Application for Non-material Amendment to Reserved Matters Approval ref. 15238/23

Plot 3, Wingates Industrial Estate, Great Bank Road

Panattoni are seeking to make non-material amendments to Reserved Matters Approval ref. 15238/23 [the RMA] in respect of an additional substation, increased provision of solar photovoltaic panels and other minor changes to external design. This necessitates the substitution of drawings and associated changes to the wording of conditions 2 (approved plans), 5 (car parking spaces), 7 (access), 9 (landscape scheme) and 14 (external lighting) attached to the RMA.

Proposed GRP Housing Details

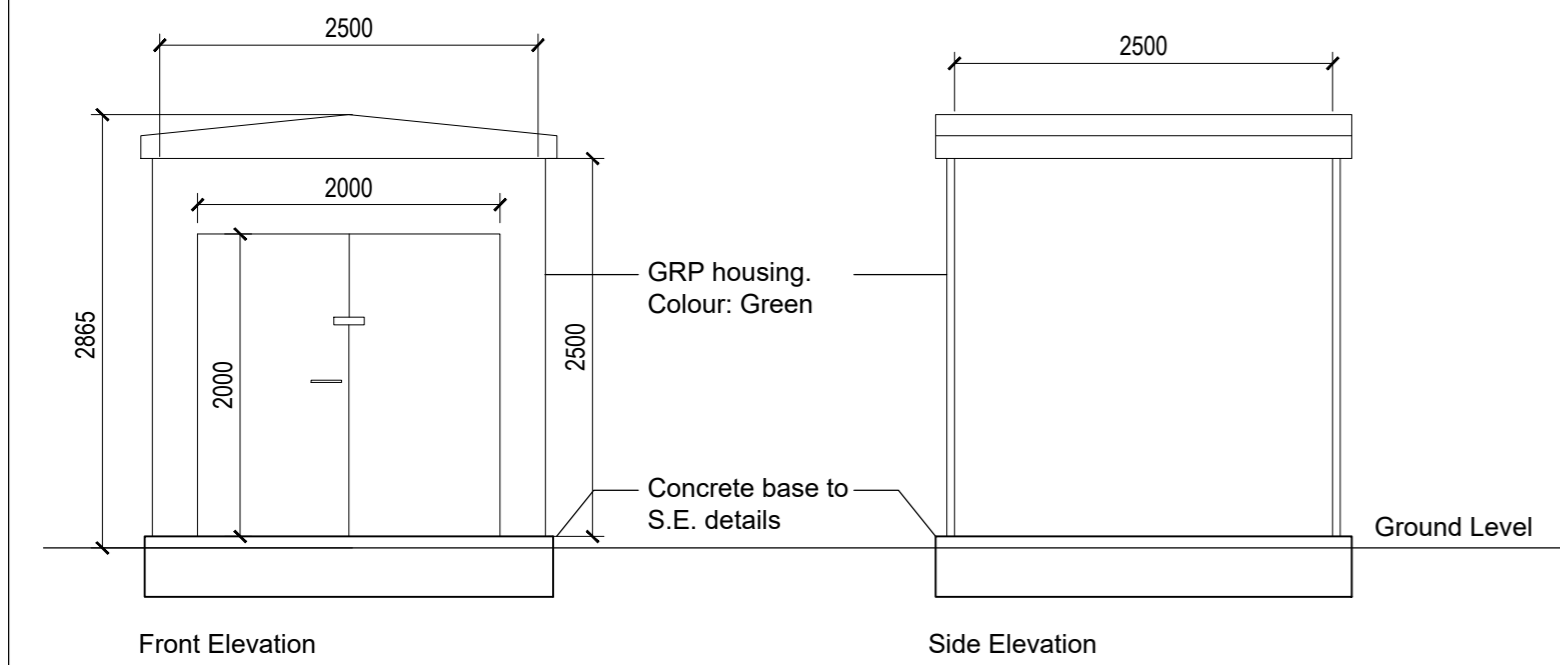
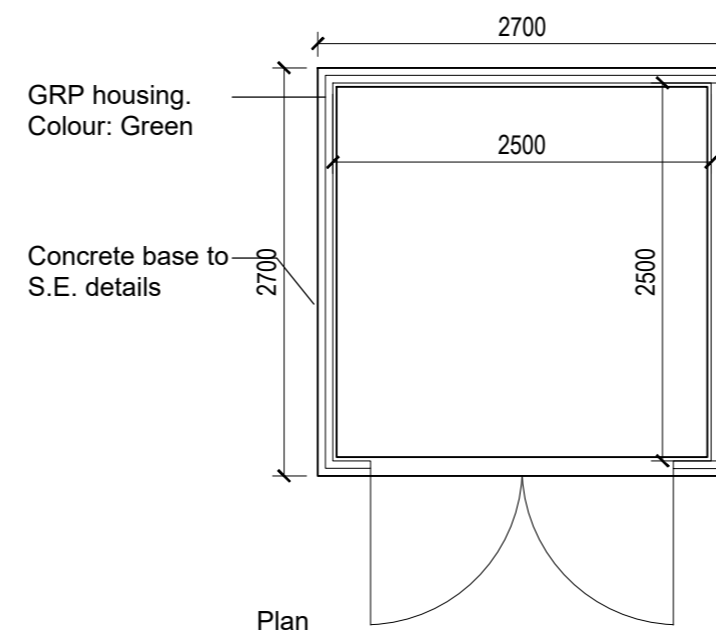
- 1 The erection of a second substation enclosure to house an automatic circuit breaker. Located in the southwest corner of the site adjacent to the approved substation and other ancillary features. It will be constructed using glass reinforced plastic, coloured green, and will measure 2,700mm in width by 2,700mm in length and 2,865mm in height.

A second substation enclosure within the curtilage of unit 3 is proposed to be located to the rear of the approved substation which faces the internal estate road. The substation is necessary due to the technical safety requirements of the building. The second substation will be located inside the perimeter fence of Unit 3, facing the car park and will be privately owned and maintained. Please refer to the accompanying Proposed GRP Housing Details Plan for full details of the proposed substation (ref. 12737-AEW-03-XX-DR-A-0520 rev. P1). The second substation will match the adjacent substation in terms of materiality and colour/finish. It will measure approximately 7.29sqm compared with circa 12.5sqm of the adjacent substation. The second substation will therefore have a smaller footprint than the first, and sit behind an area of landscaped planting which will reduce its visibility. Trees comprising *Acer campestre* 'Elsrijk' and *Pyrus Chanticleer* are located either side of the approved substation. These trees can reach heights of up to 12m with an ultimate spread of 4-8m. Based on the reduced size of the second substation, the positioning behind the existing substation and the soft landscaping which will conceal it, it is considered that the second substation will not be discernible when viewing the site from Great Bank Road. It is therefore considered to be a non-material change to the approved development.

Title: **UNIT 3 EXTERNAL LIGHTING ELEVATION**

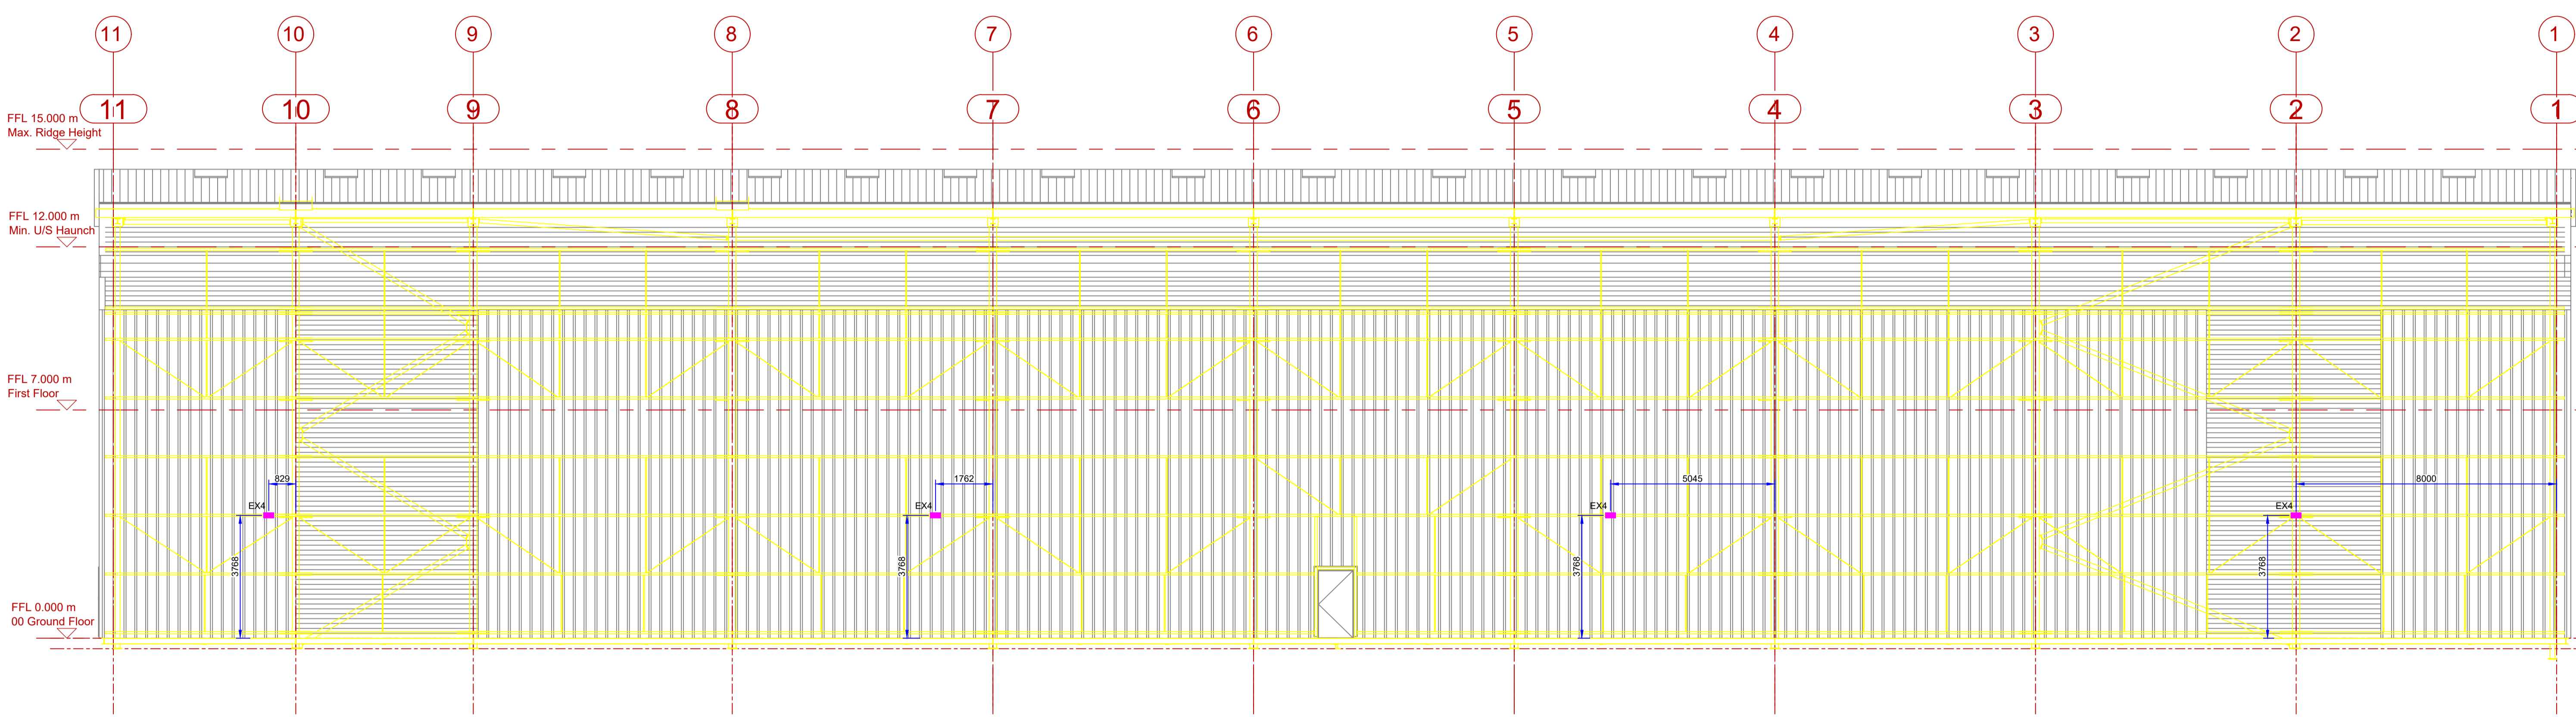
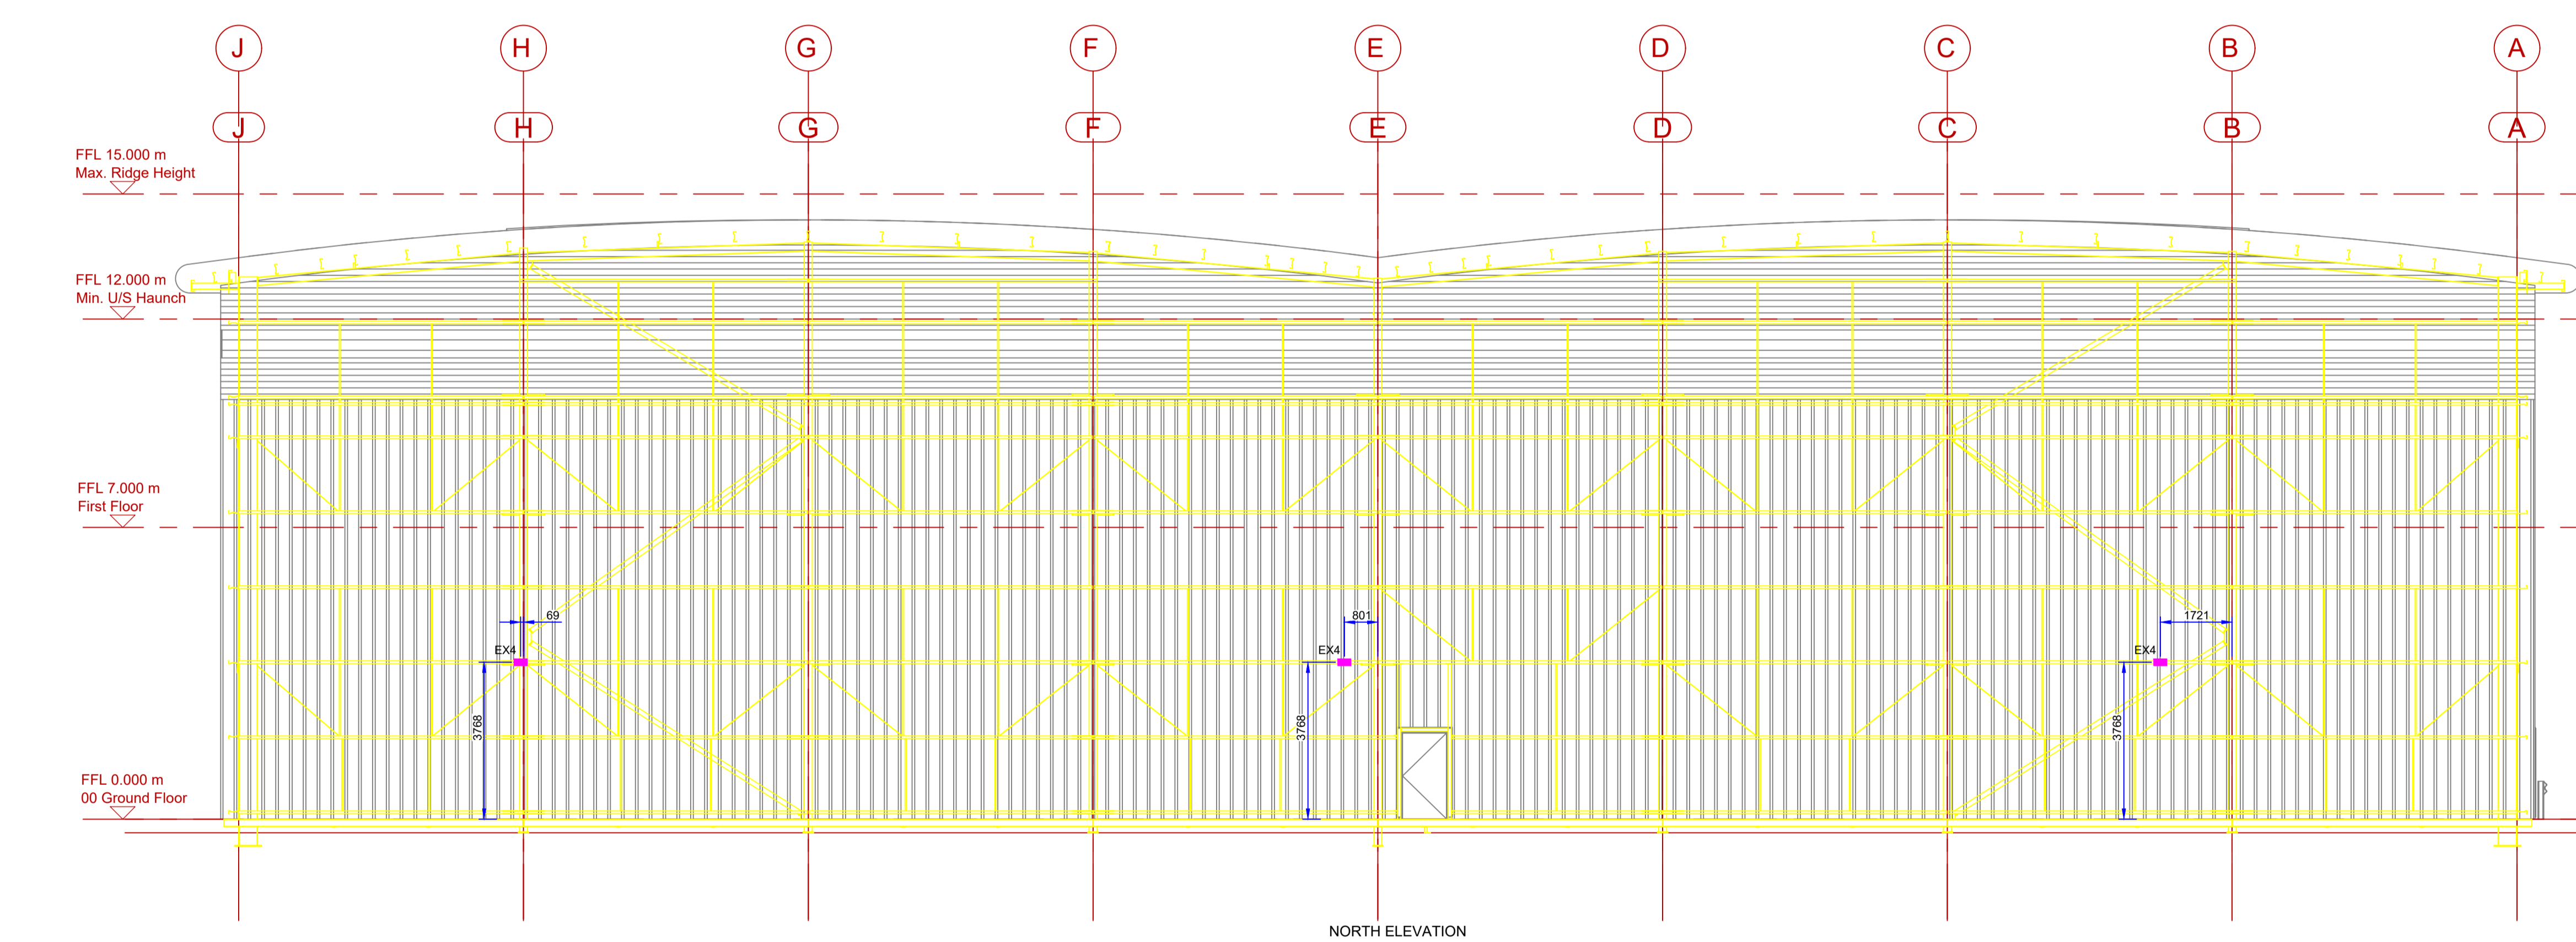
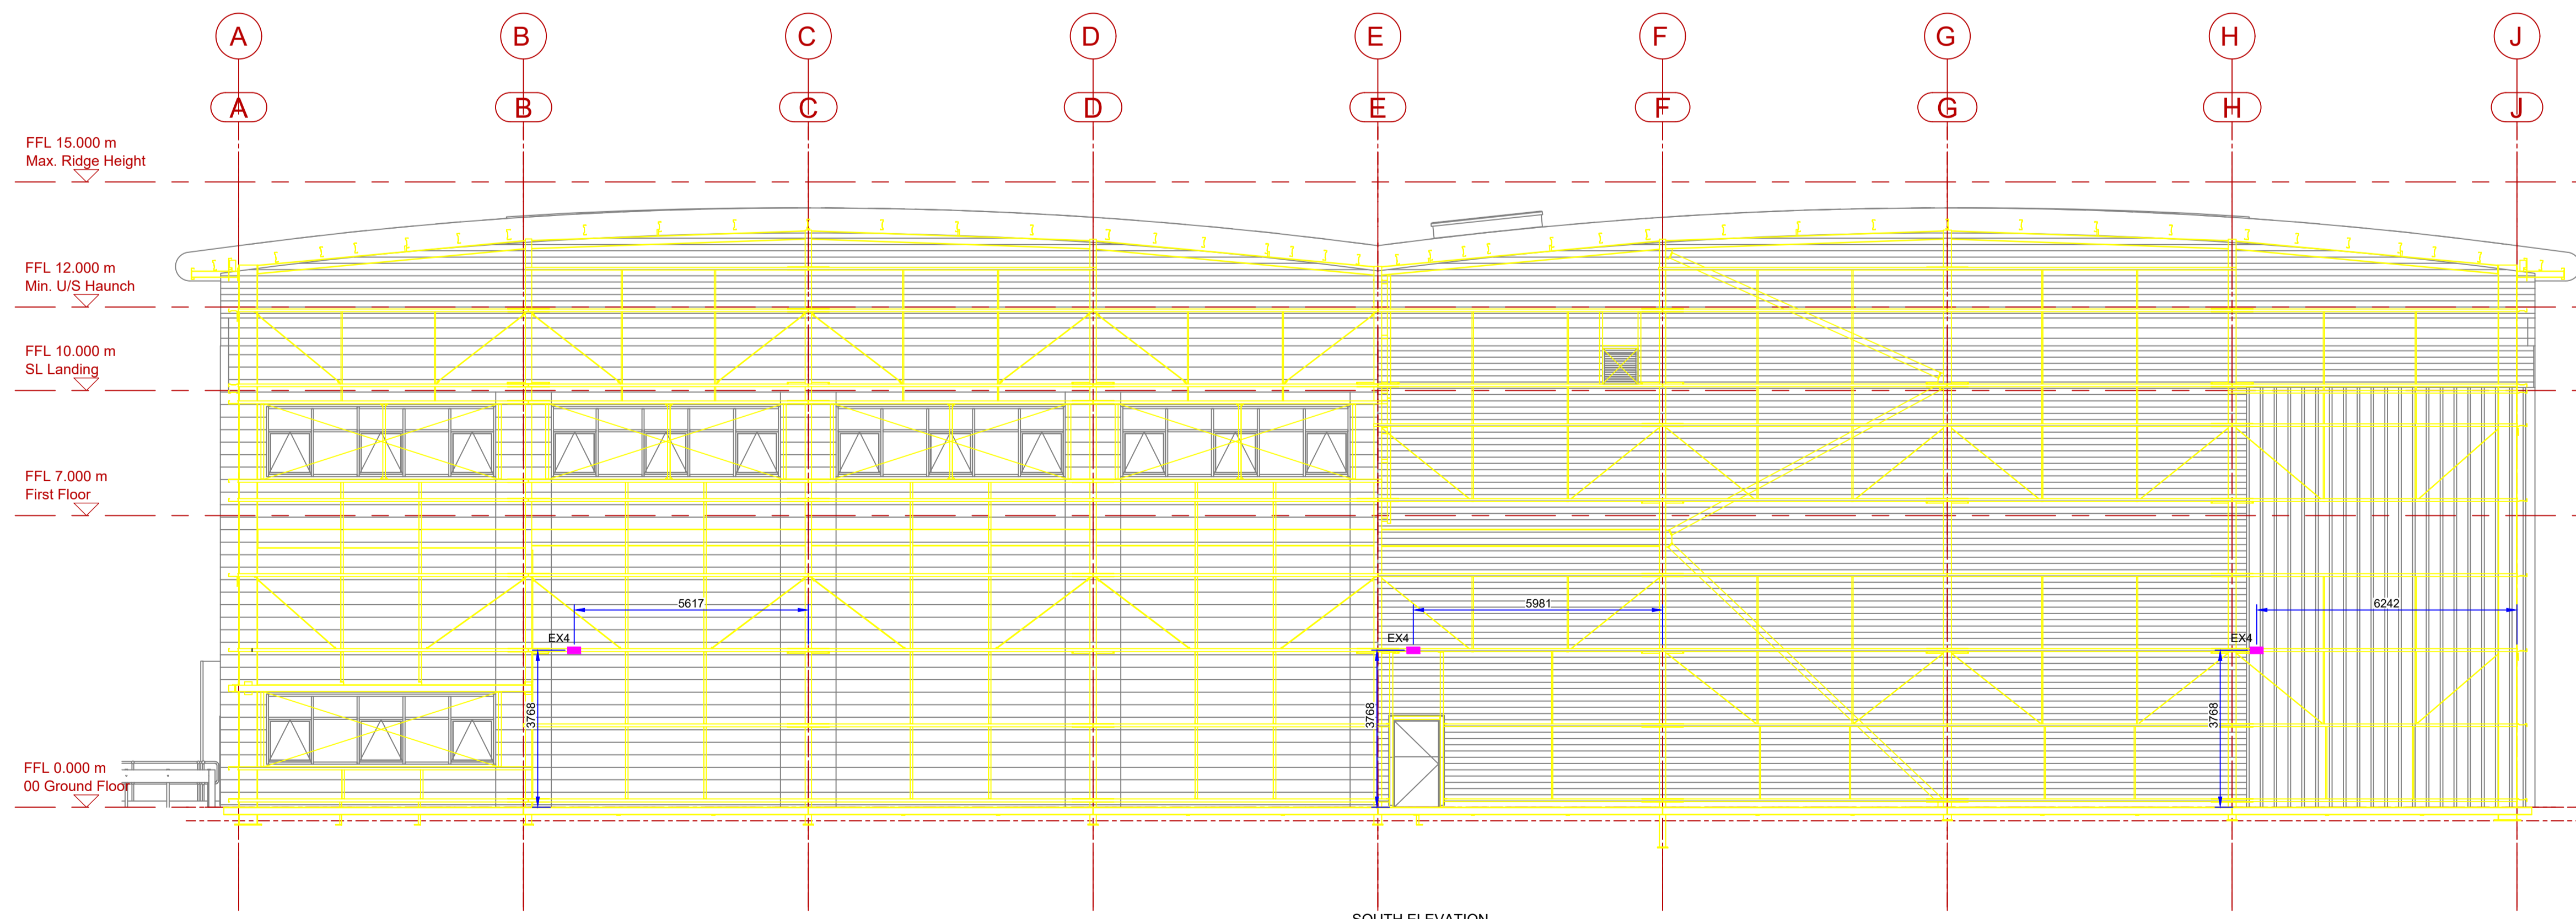
With regards to the external lighting of the main entrance, the two proposed wall mounted fixtures (EX3) will project from the western elevation of Unit 3 and will illuminate the ground below. Please refer to a comparison of the approved and proposed lighting plans in Figure 1 below. The levels of illumination are detailed on the Unit 3 External Lighting and Lux Plot Layout Plan, a snippet of which is used in Figure 1 (ref. P23012-EBM-EX-XX-DR-E-0931 rev. P2). This demonstrates the illumination

*“External lighting / floodlighting shall be installed as set out in the **following plans: Unit 3 External Lighting & LUX Plot Layout ref. P23012-EBM-EX-XX-DR-E-0931 rev. P2 and Unit 3 External Lighting Elevation ref. P23012-EBM-EX-XX-DR-E-0933 rev. P1.** external lighting report submitted with the application, Wingates Plot 3, by CPWP, reference 220512 Rev P01, dated 18/11/22. The lighting shall be designed to an illumination value of no more than 5 lux at the nearest residential property. The beam angle of any lights directed towards any potential observer should be kept below 70 degrees. Spill shields should also be fitted (if necessary). The approved scheme shall be implemented in full before the development is first brought into use and retained thereafter.”*
